From: [REDACTED]
To: [Metrowest1](#)
Subject: Register Objection
Date: 22 November 2020 21:12:12

I would like to register my objection to the proposed Trinity footbridge, whilst I appreciate my neighbours Mr & Mrs Sanders have already raised similar concerns, we would like to make our objection clear and ask some further questions with regards the Applicants responses to the initial questions posed by Mr & Mrs Sanders.

Figure 3-9: Trinity Pedestrian Footbridge General Arrangement (sheet 1)

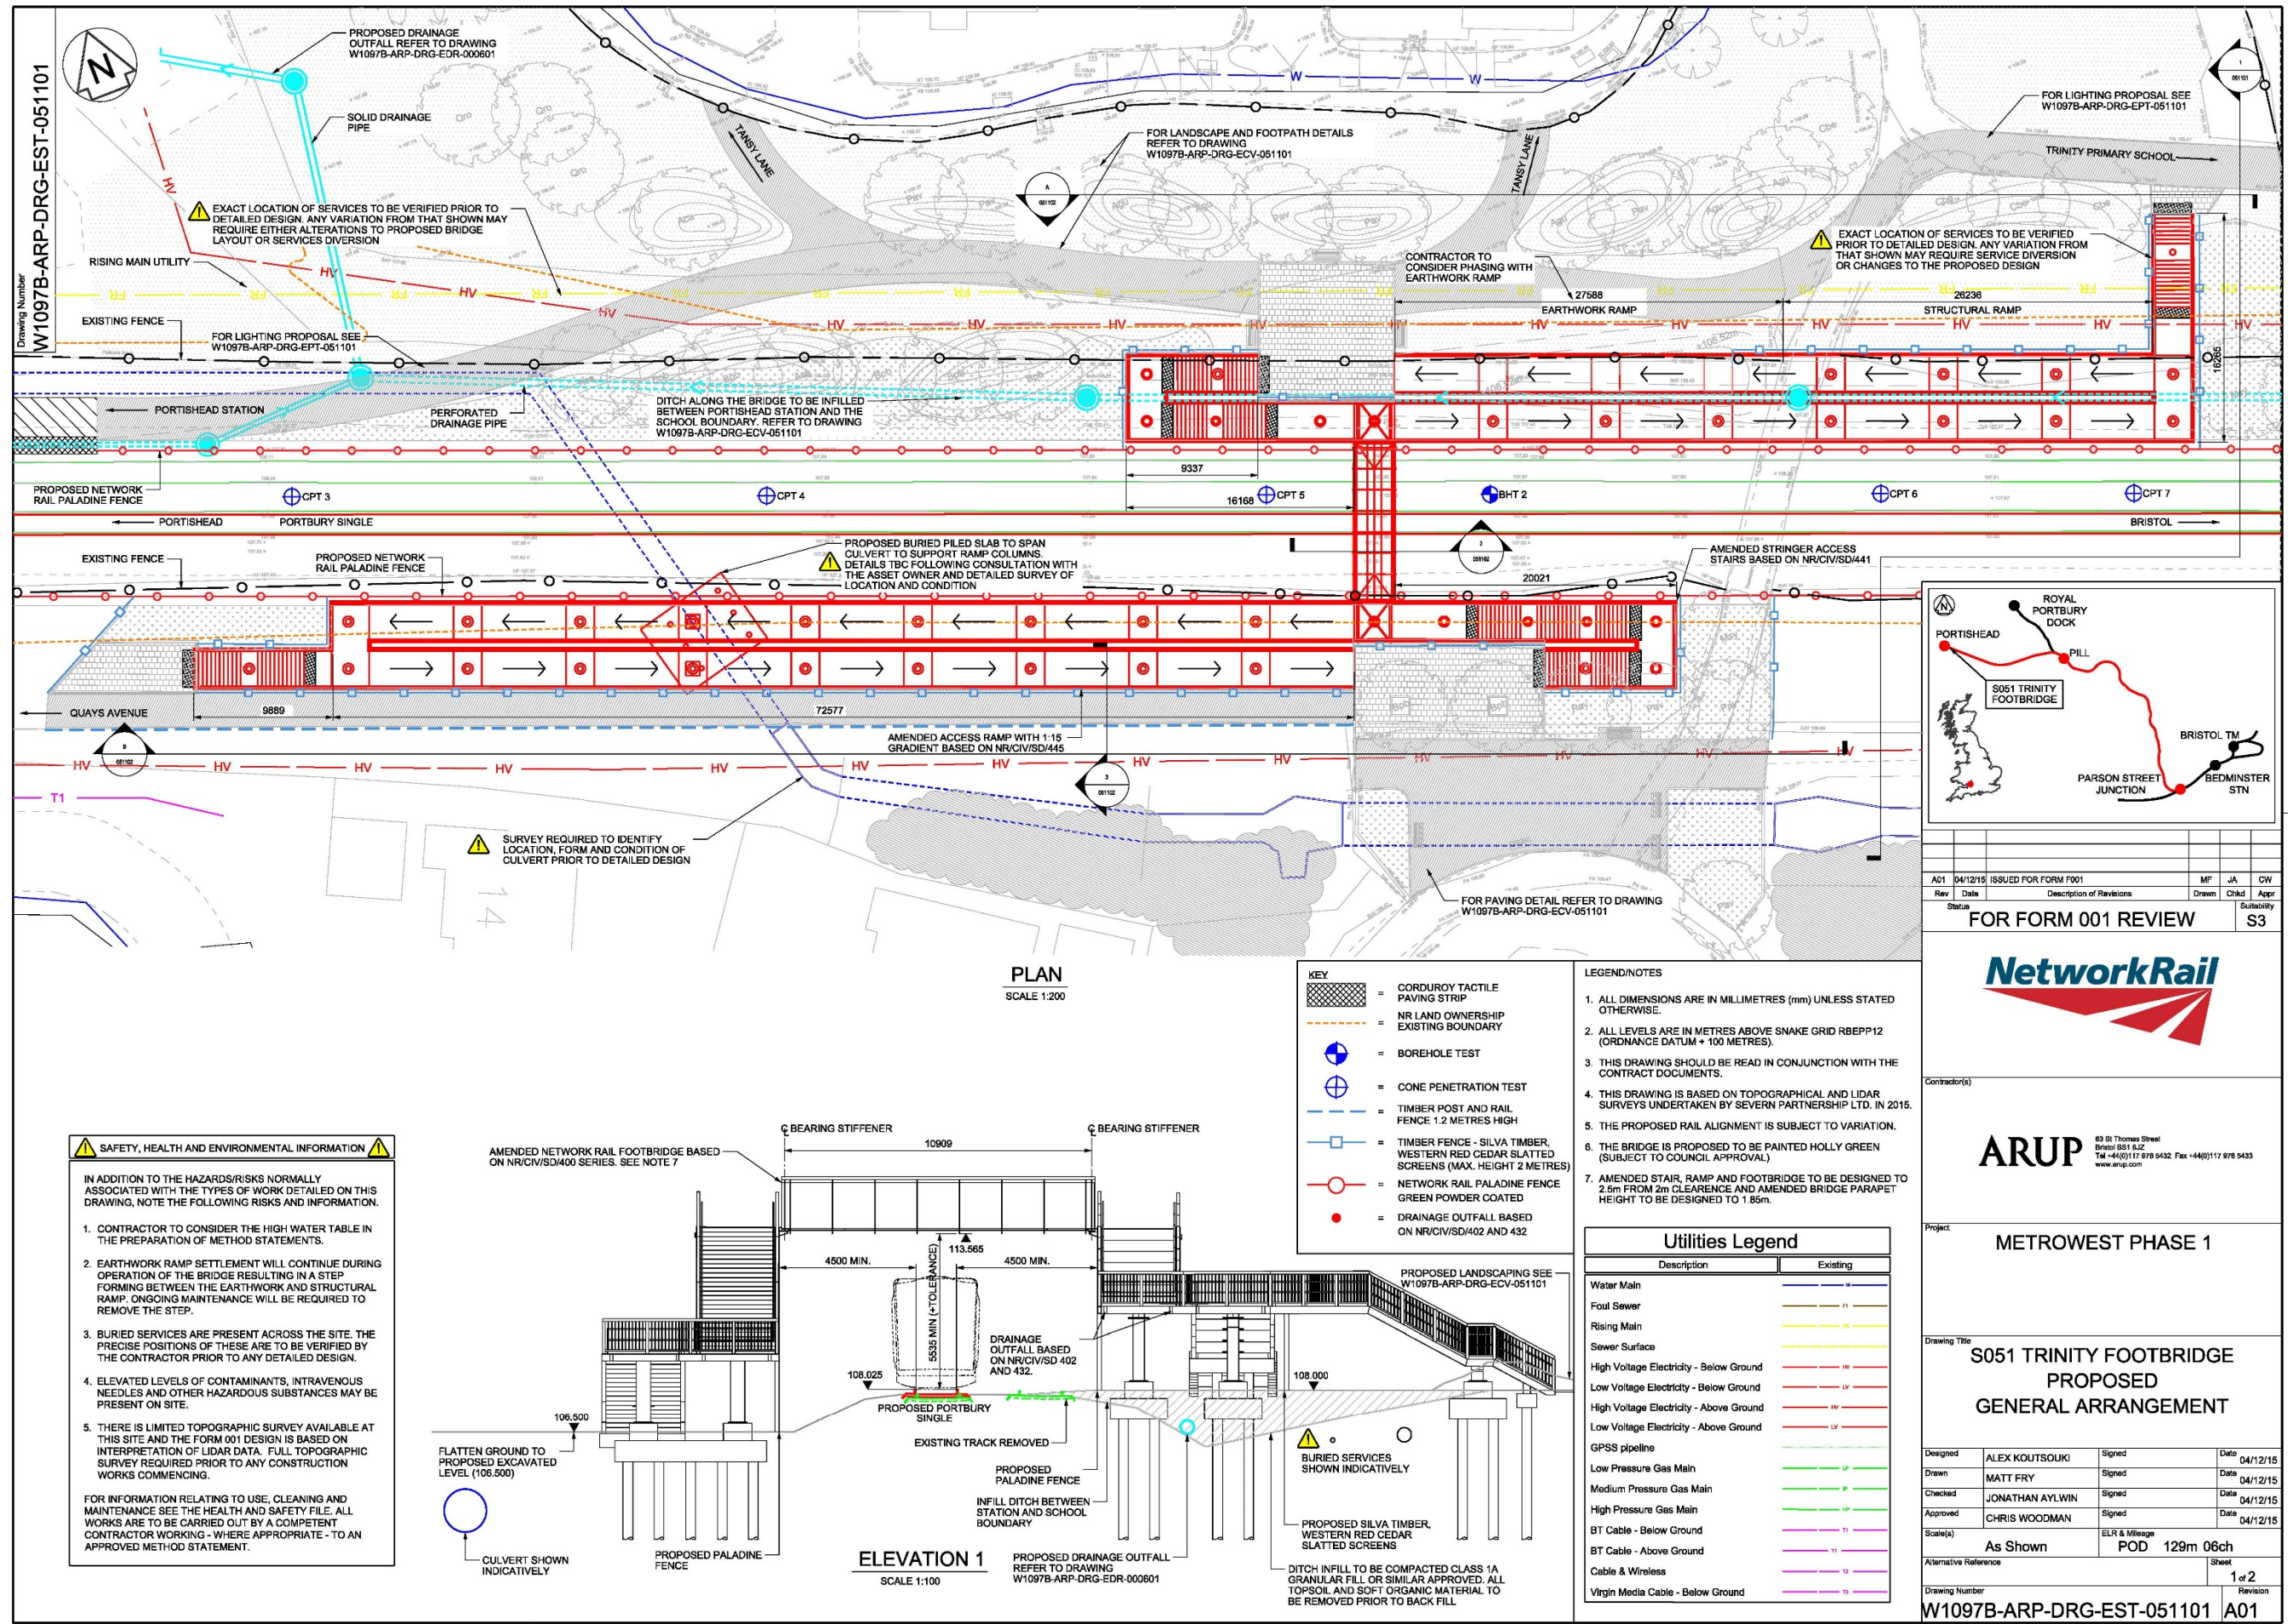
- Dog walkers - they are out for a walk an additional 100 meters would be not an issue.
- General walkers - they are out for a walk an additional 100 meters would be not an issue.
- Bikes - Will bikes be allowed to ride on the bridge? Most will opt to stay on the flat and use the new proposed footpaths and not have to navigate the multiple tight turns proposed and a 1:15 incline.
- Scooters/Skateboards - Will they be allowed to ride on the bridge?

The response by the Applicant in 9.5 ExA.OFH.D1.V1 with regards the design of the bridge does not address any of the privacy and noise concerns that all local property owners have with regards the proposed bridge. The design justification

- Would it be possible to see a series of pictures from various locations and heights of the proposed footbridge design into all properties so this can be assessed?

- Would it be possible to clearly identify and mark all trees that will remain so we can understand the 'possible' screening suggested?
- Can the applicant commit to significant planting of mature trees? If so, how many, what size and what location?

- Could you please replicate the lighting proposed so we can all experience what 500 LED lights flashing on and off all night and see how that will impact our children sleeping in their bedrooms?

- Will there be CCTV on the bridge, if so can you please provide a clear statement of what views will be monitored and offer sample views to all neighbouring properties?

We would also be keen to know what will be in place to stop motorised scooters and mopeds from using the bridge, there is an existing issue where mopeds/motorcycles use the current crossing at night, what will you have in place to stop this?
